# CITY OF ALBUQUERQUE

April 15, 2019

RE: **Montgomery Carwash**  
**3525 Montgomery NE**  
**Grading Plan Stamp Date: 4/1/19**  
**Hydrology File: F16D053**

Based on the submittal received on 4/15/19, the Grading and Drainage Plan is approved for Building Permit.

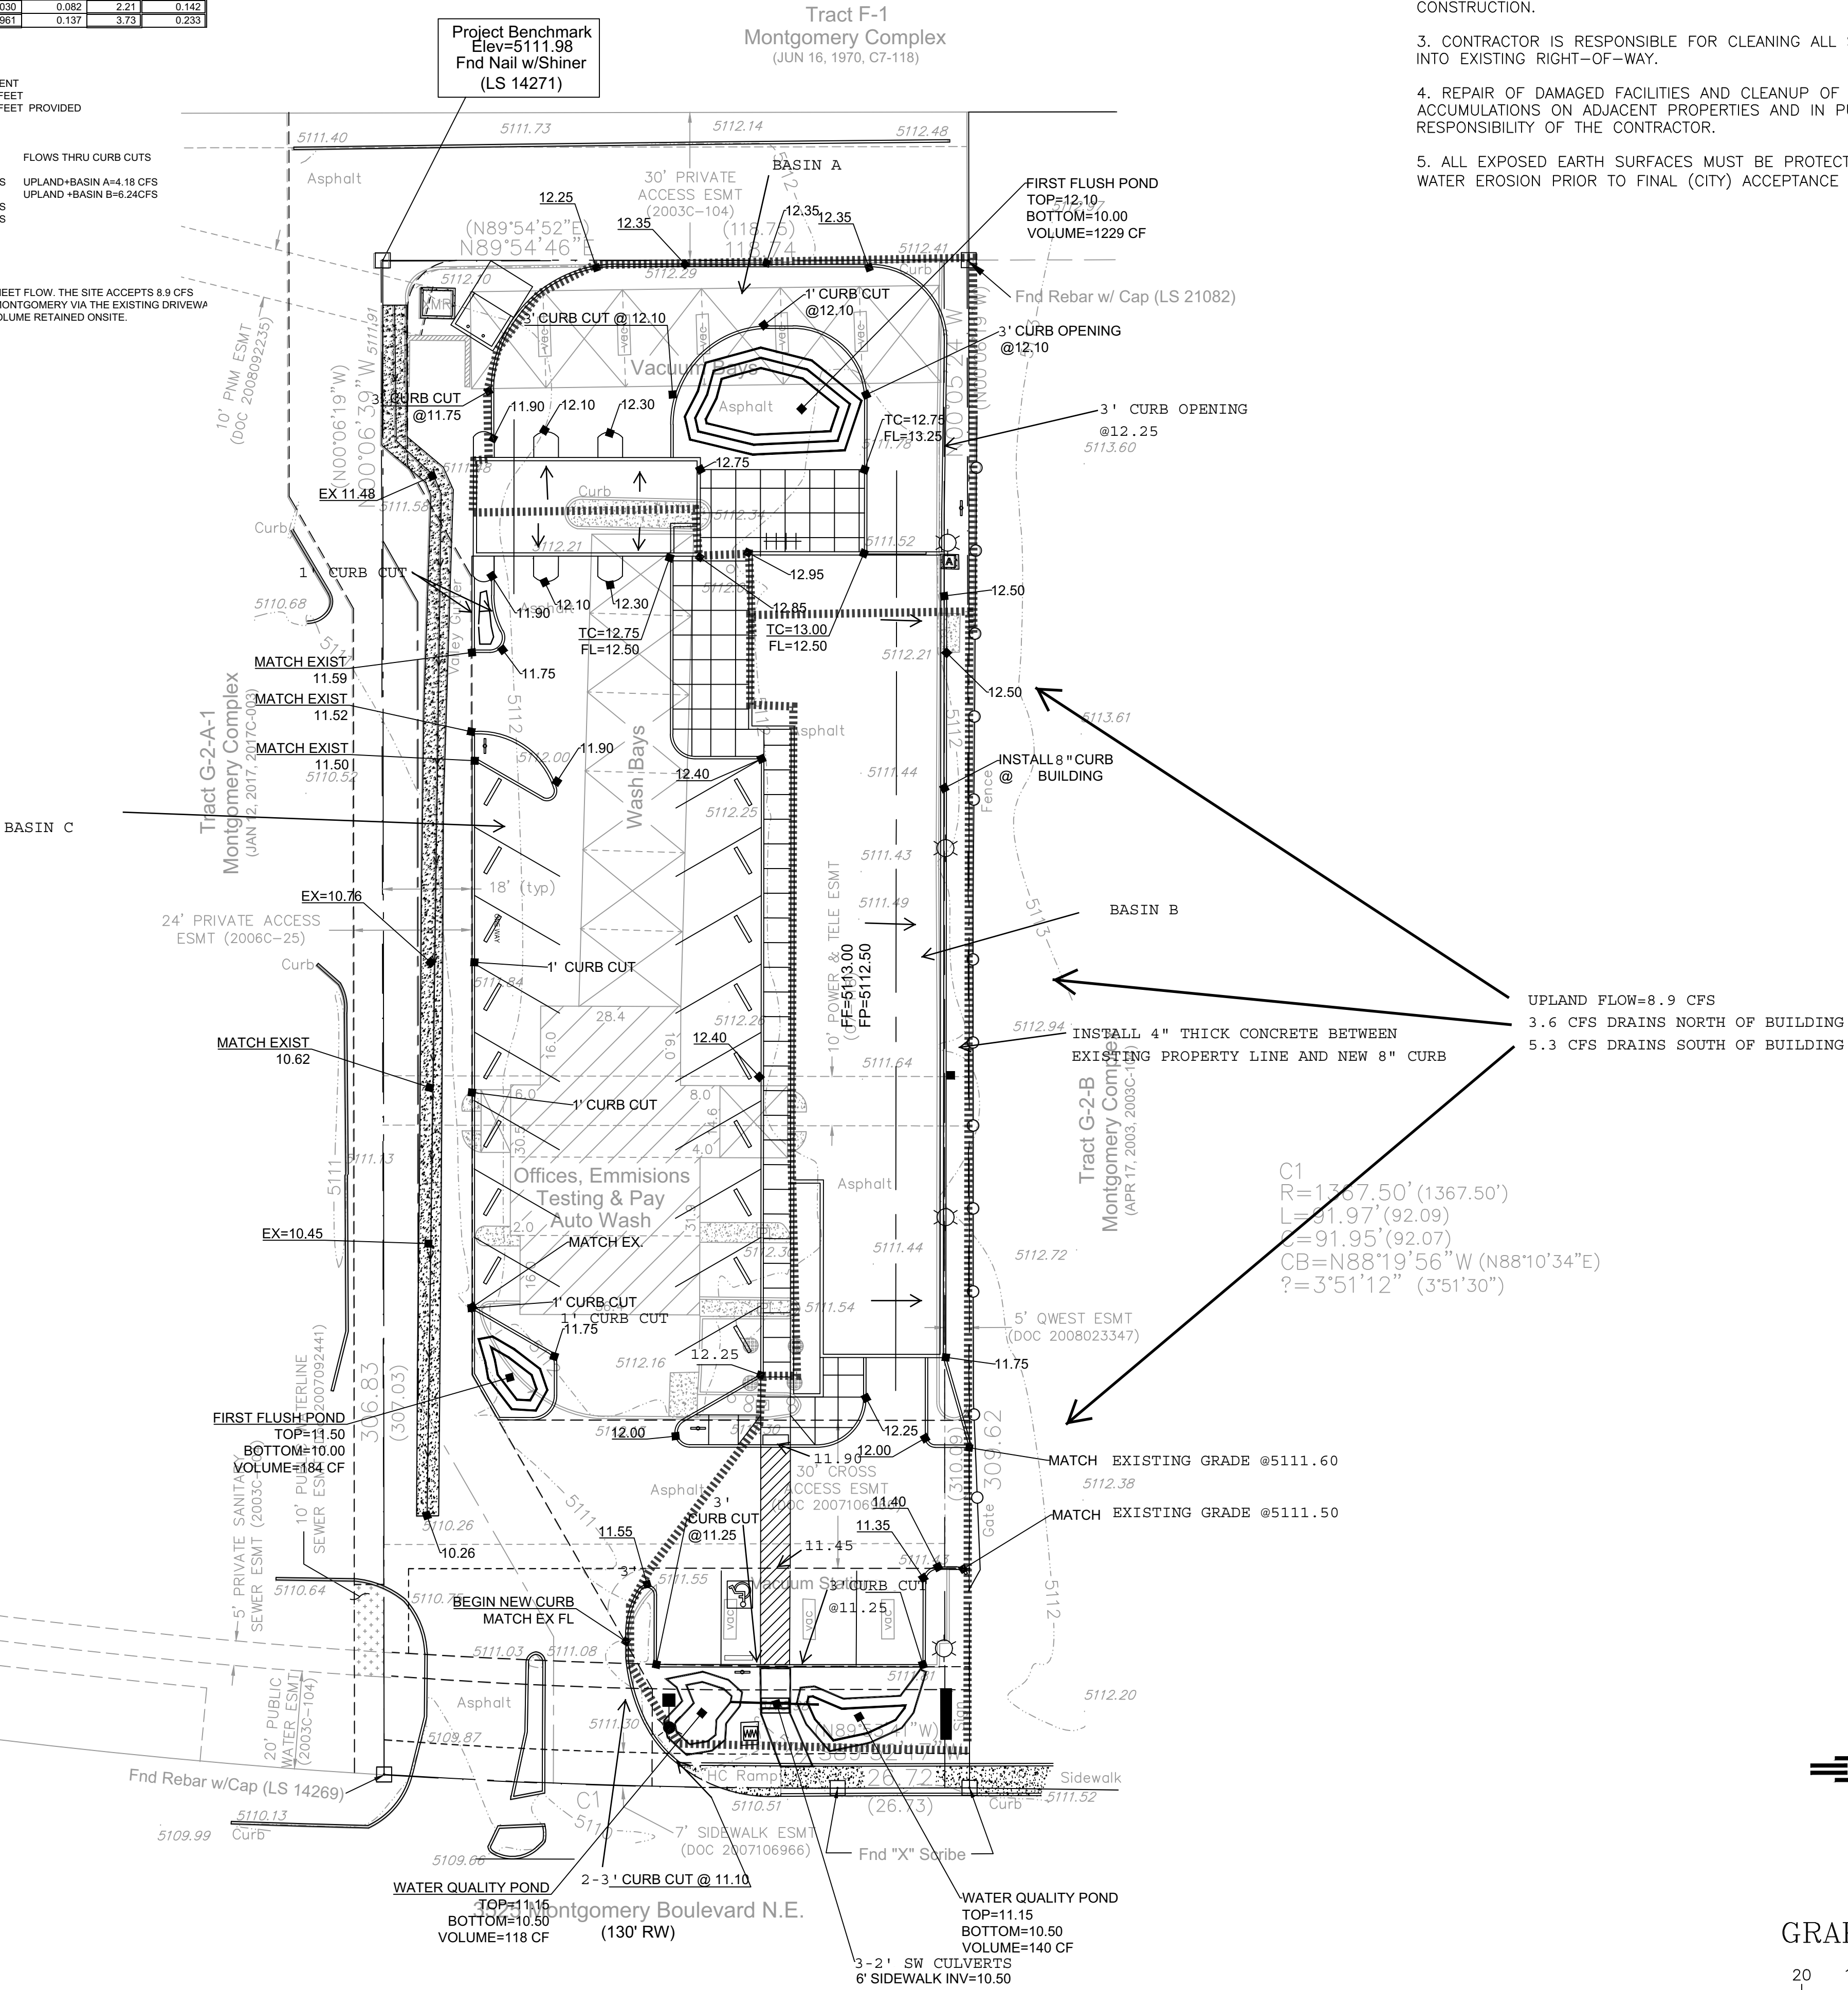
1. Basin C delineation needs to be shown on the plan. It is unclear how any of Basin C makes it to a stormwater quality pond.

3. Each stormwater quality pond need to be sized for the area draining to it. These areas need to be clearly delineated and shown on the plan, or as a separate exhibit.

**WE HAVE PROVIDED BASIN AND POND SUBBASINS ON PLAN**

**WE HAVE PROVIDED SUBBASIN BOUNDARIES AND INCLUDED IN CALCULATIONS**

TYPICAL SECTION AT EAST PROPERTY LINE

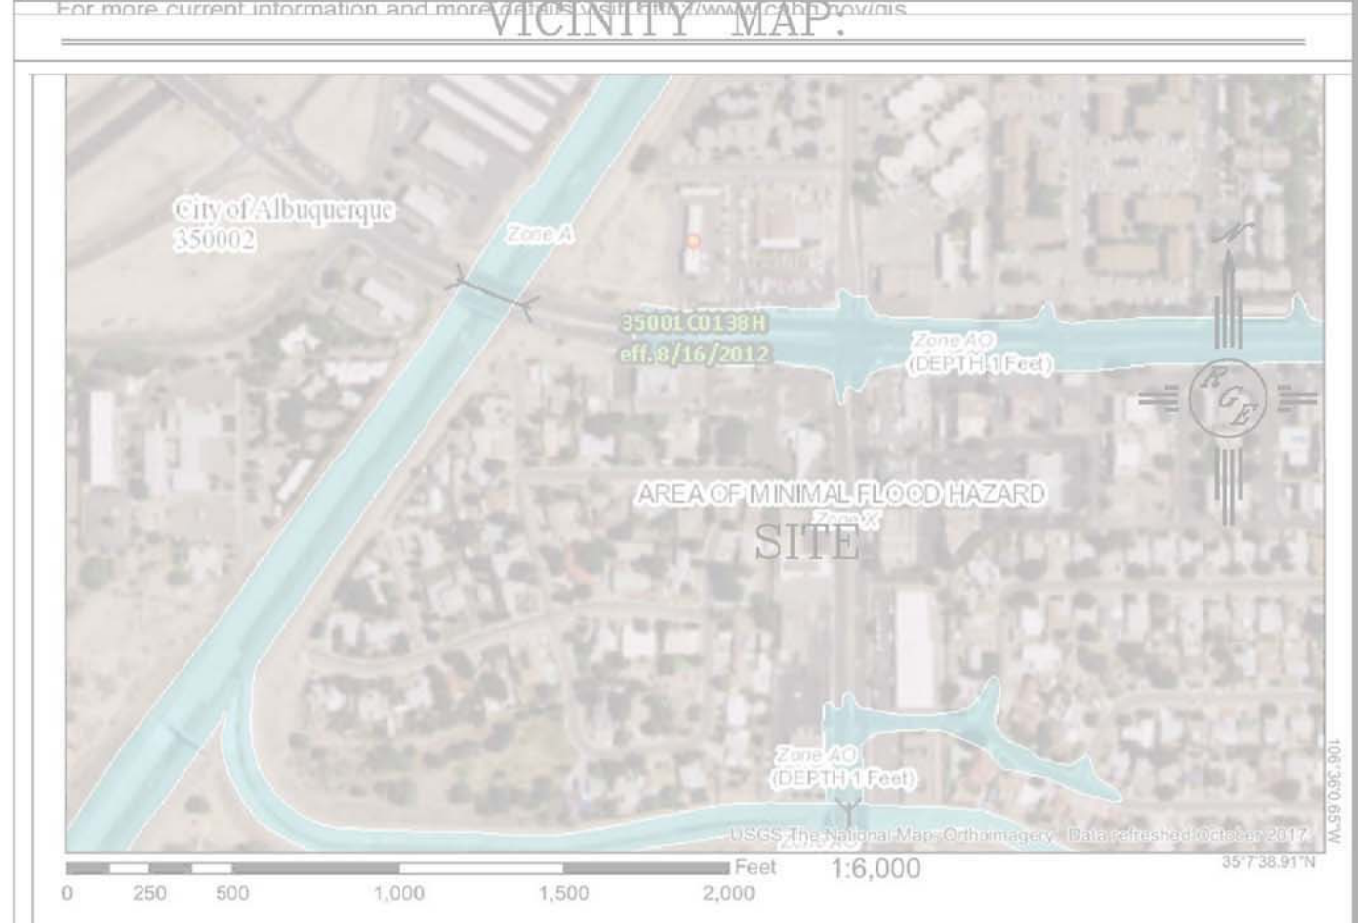
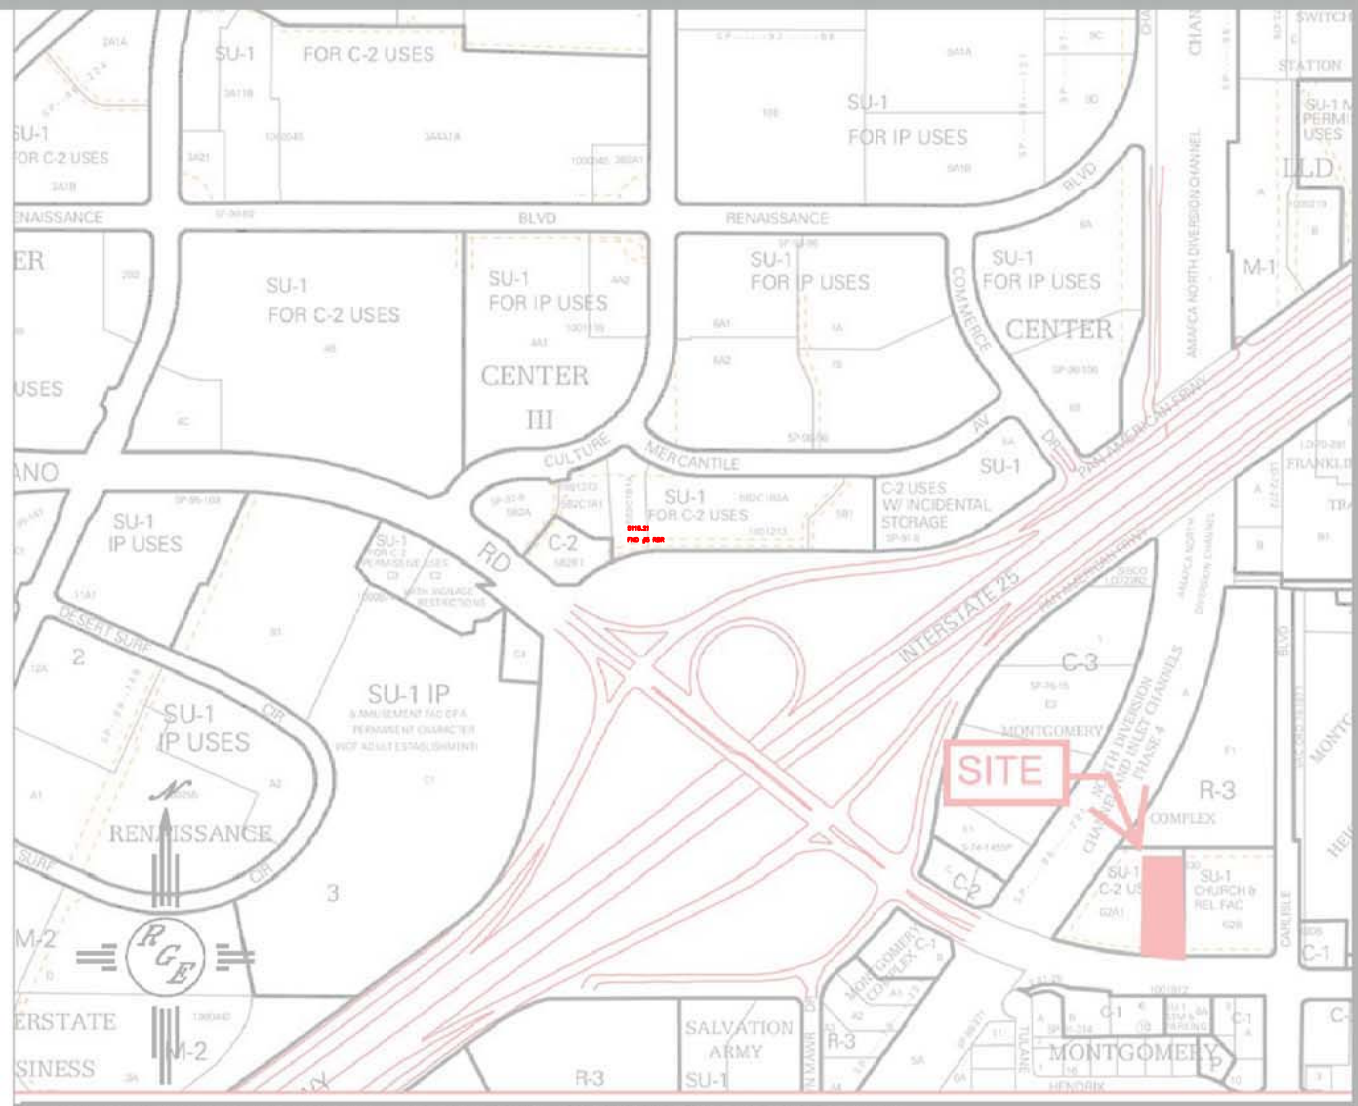
4. Provide a section through the building and east property line. How will the channel manage the roof runoff and the offsite flows? Please show the channel in plan view.

**SECTION AND PLAN VIEW HATCHING OF CHANNEL PROVIDED**
